ATTACHMENT A – DETAILED RESPONSE TO SUBMISSIONS TABLE

Table 1 – Record and response to submissions to SSD 10822510

drawing
Shadow Analysis

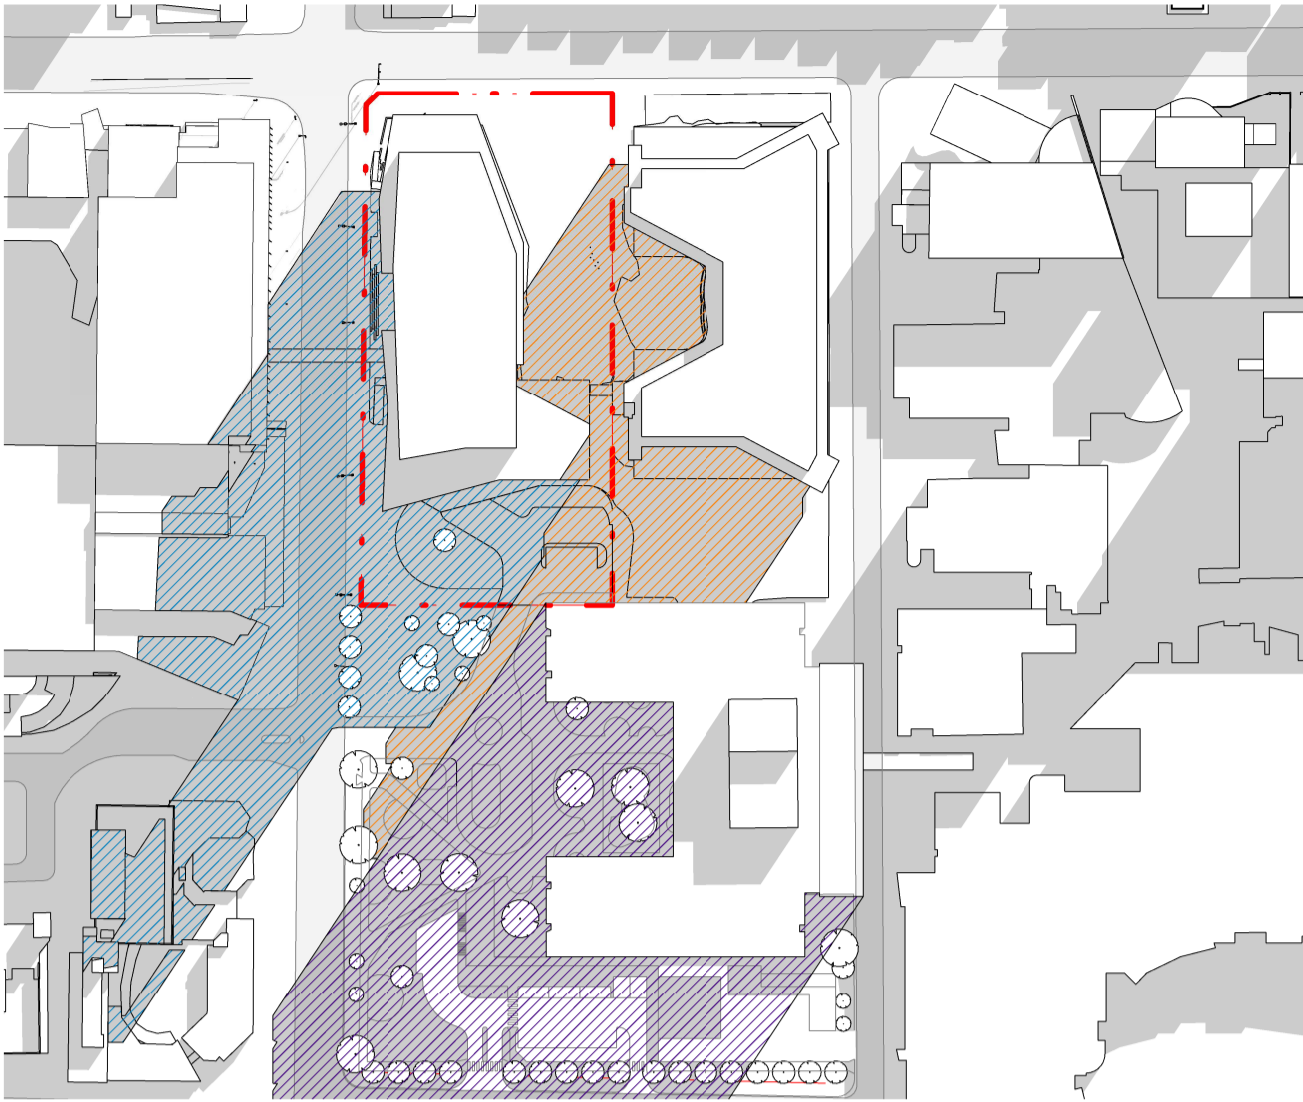
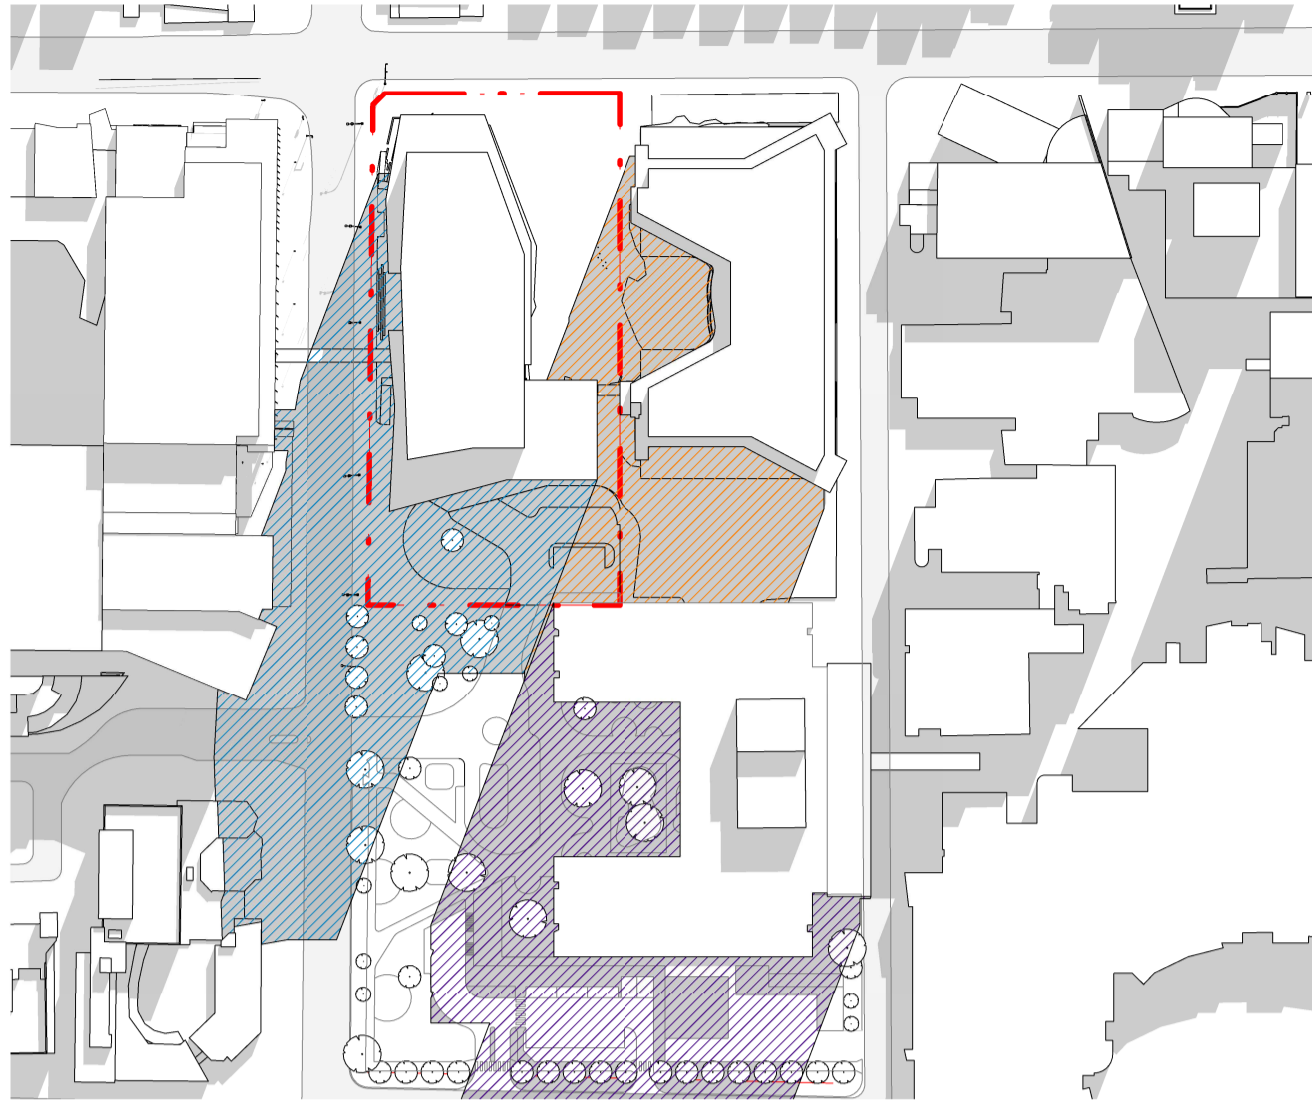
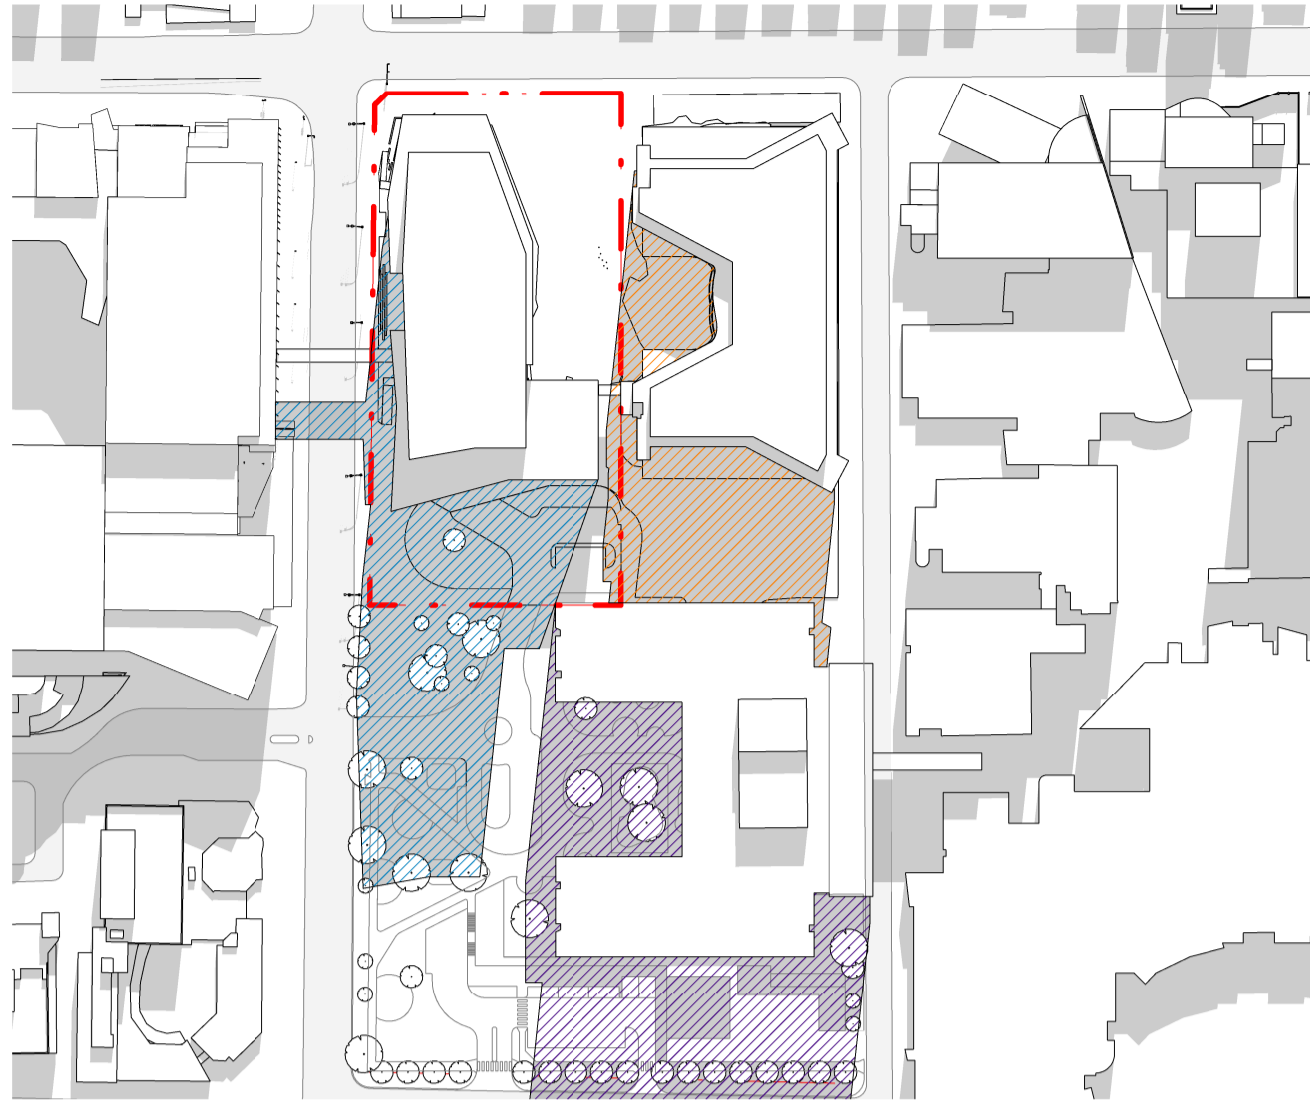
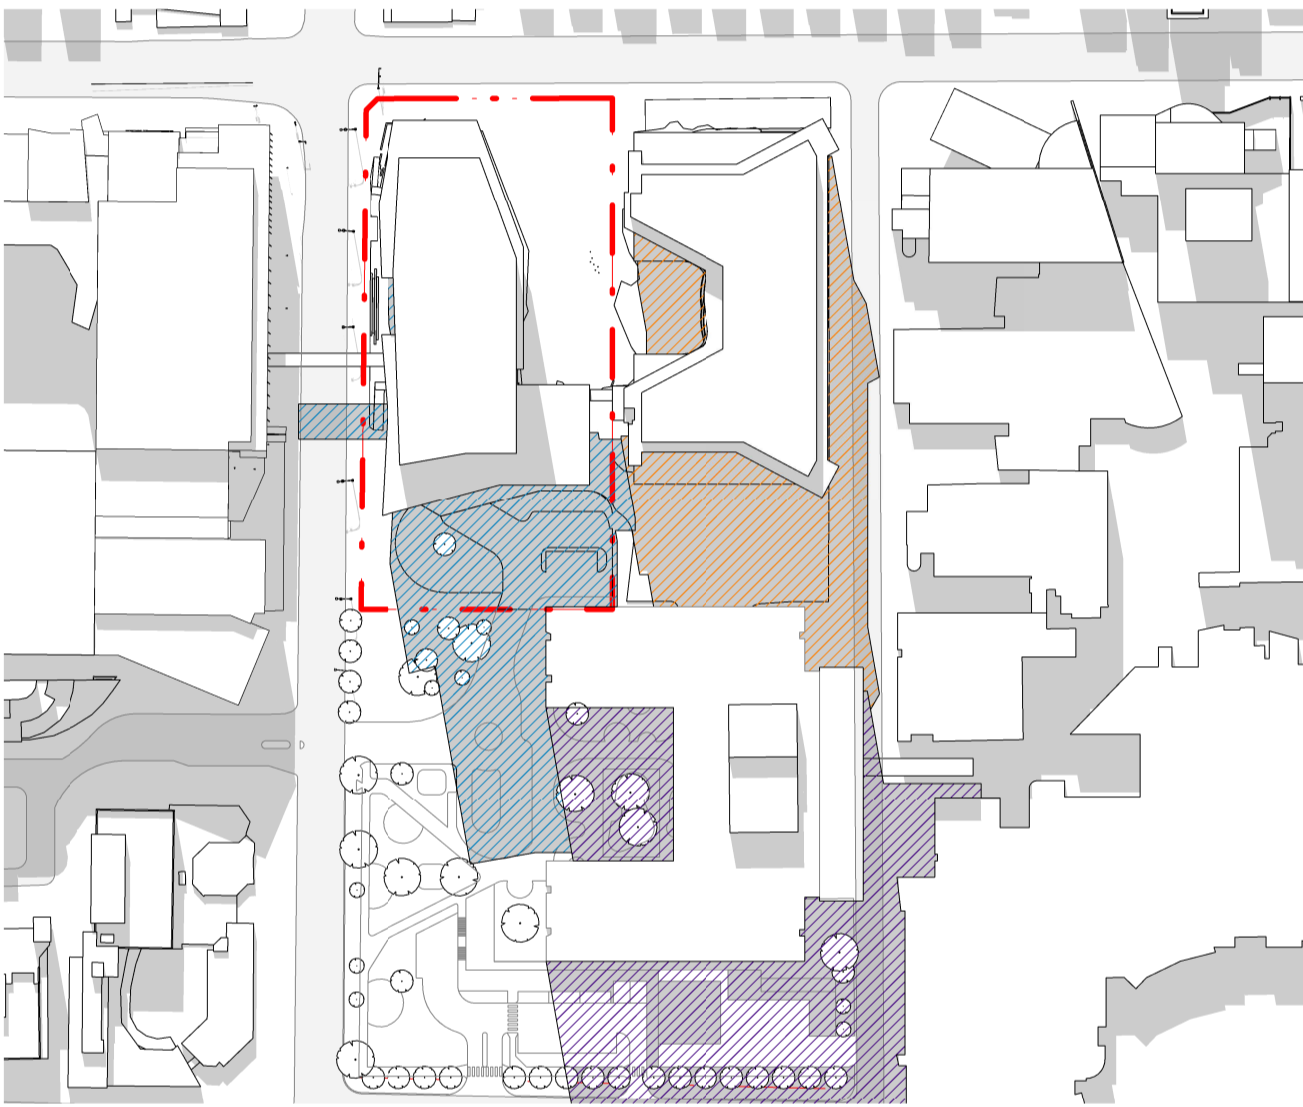
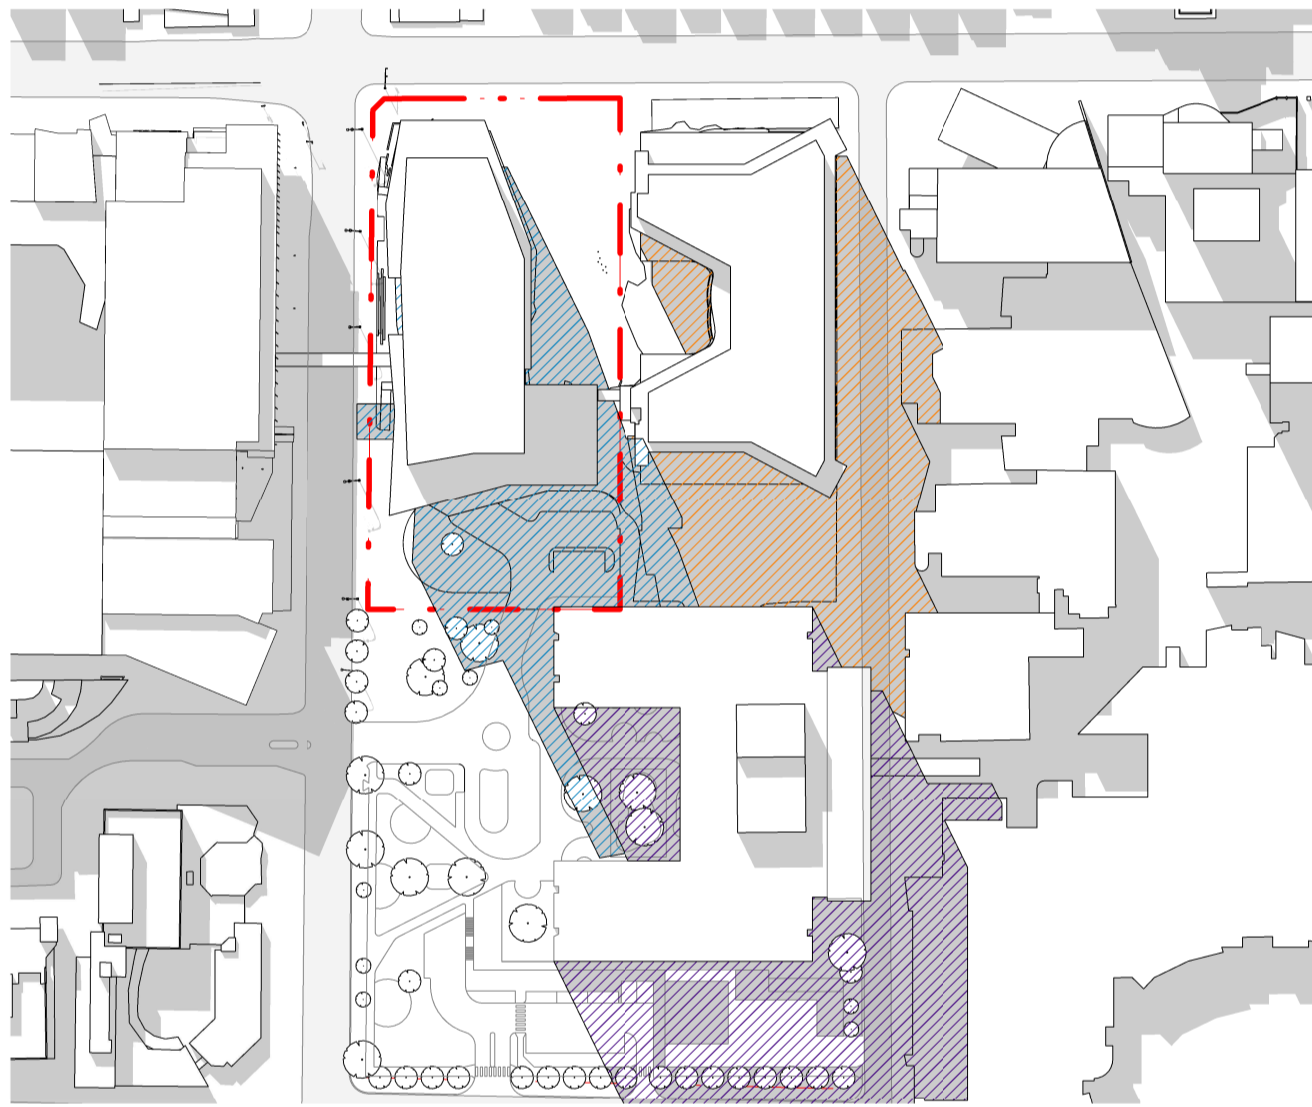
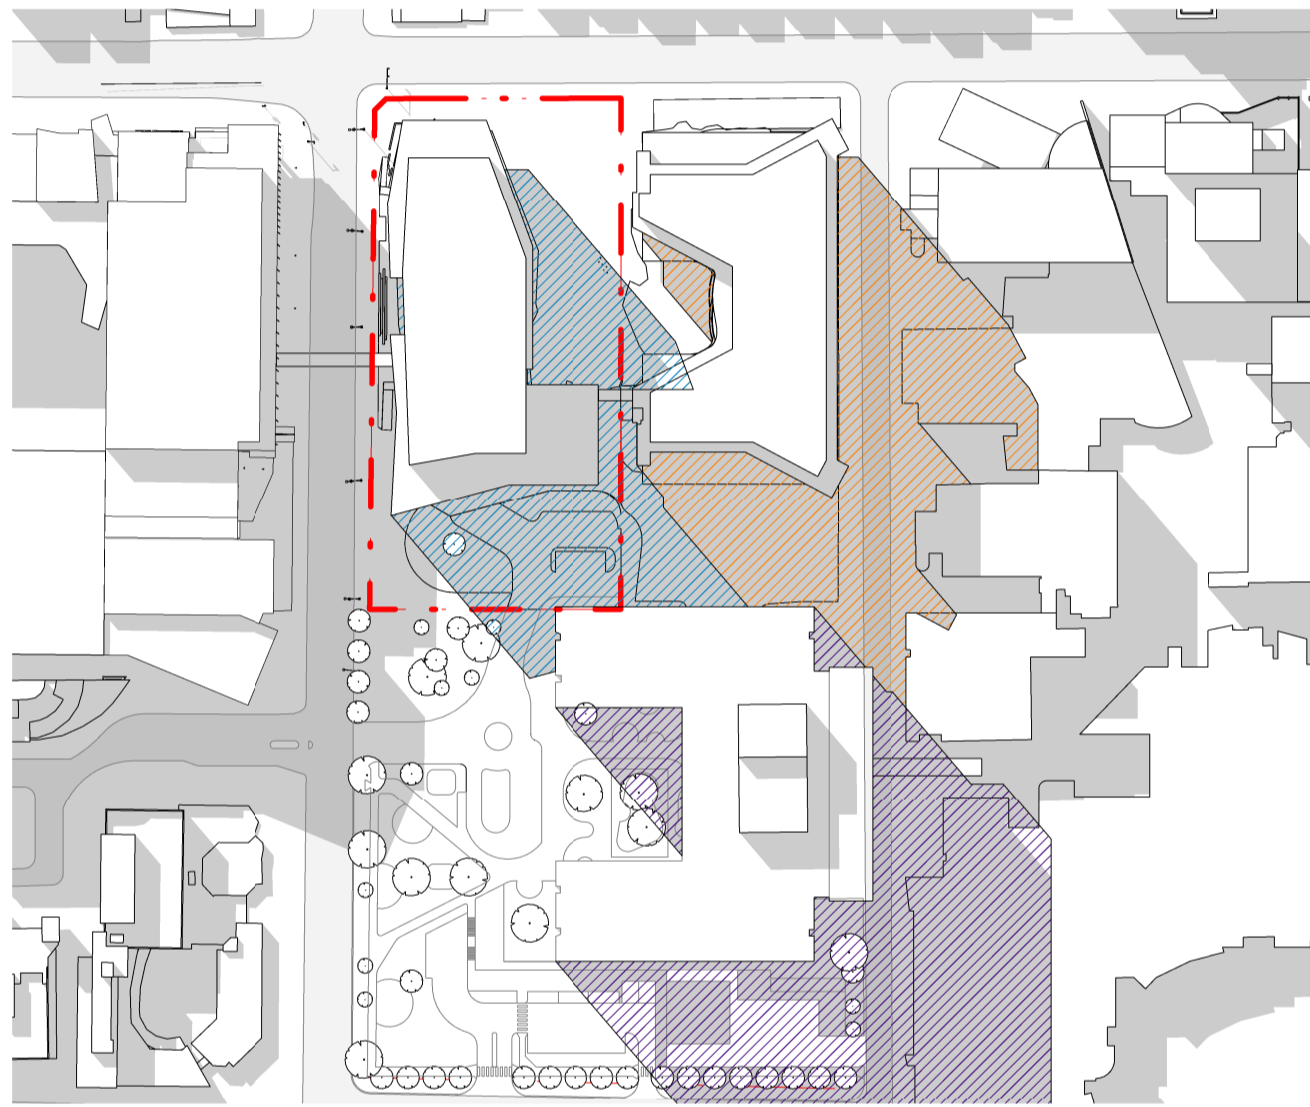
17			<i>It appears that the current southern leg of the UNSW HTH building will overshadow the Children's Hospital emergency vehicular drop off loop and pedestrian waiting area, as currently configured, for most of winter months.</i>	<p>Overall, the shadow diagrams demonstrate that:</p> <ul style="list-style-type: none"> At all times of the day on the Winter Solstice, the IASB will overshadow all or part of the U-shaped space at the entry to the IASB (the IASB entry forecourt); Between 10am and 3pm on the Winter Solstice, parts of the hospital access area and vehicular drop-off / pick-up will receive some solar access. There are significant areas of solar access available between 12pm – 2pm; and From 2pm onwards, existing buildings on the UNSW Kensington Campus will overshadow all or part of the IASB forecourt and hospital access area and vehicular drop-off / pick-up.
18			<i>The shadow diagrams provided are limited, addressing only the early morning, midday and late afternoon. Hourly shadow diagrams at the June 21 should be provided to assess solar access and amenity.</i>	<p>With respect to the impact of the UNSW HTH, the shadow diagrams demonstrate that:</p> <ul style="list-style-type: none"> The UNSW HTH will have a minimal impact on the IASB entry forecourt; The UNSW HTH will overshadow parts of the hospital access area and vehicular drop-off / pick-up between 9am and 12pm on the Winter Solstice, however shadows are largely limited to the access roads and circulation spaces; and From 1pm onwards, the UNSW HTH will have a limited impact on the hospital access area and vehicular drop-off / pick-up.

Item No	Name	Type	Issue	Response
				Based on the above, it is considered that the overshadowing impacts associated with the UNSW HTH are acceptable. Despite the UNSW HTH, parts of the hospital access area and vehicular drop-off / pick-up will receive solar access between 10am and 3pm on the Winter Solstice, providing opportunity for visitors to find areas of sunlight, if desired. Further, as part of the UNSW HTH, a large, north-facing publicly accessible plaza will be provided which will receive ample solar access on June 21.
19			High Street frontage street wall datum <i>The UNSW HTH building along the northern High Street frontage is eight storeys which maintains the emerging seven to eight storey street wall height along this street frontage. The 6m ground level setback and the additional upper level tower setback of approximately 9.6m is supported, as it will reduce the apparent tower building height and help to mitigate the potential scale impacts upon the High Street streetscape.</i>	Noted.
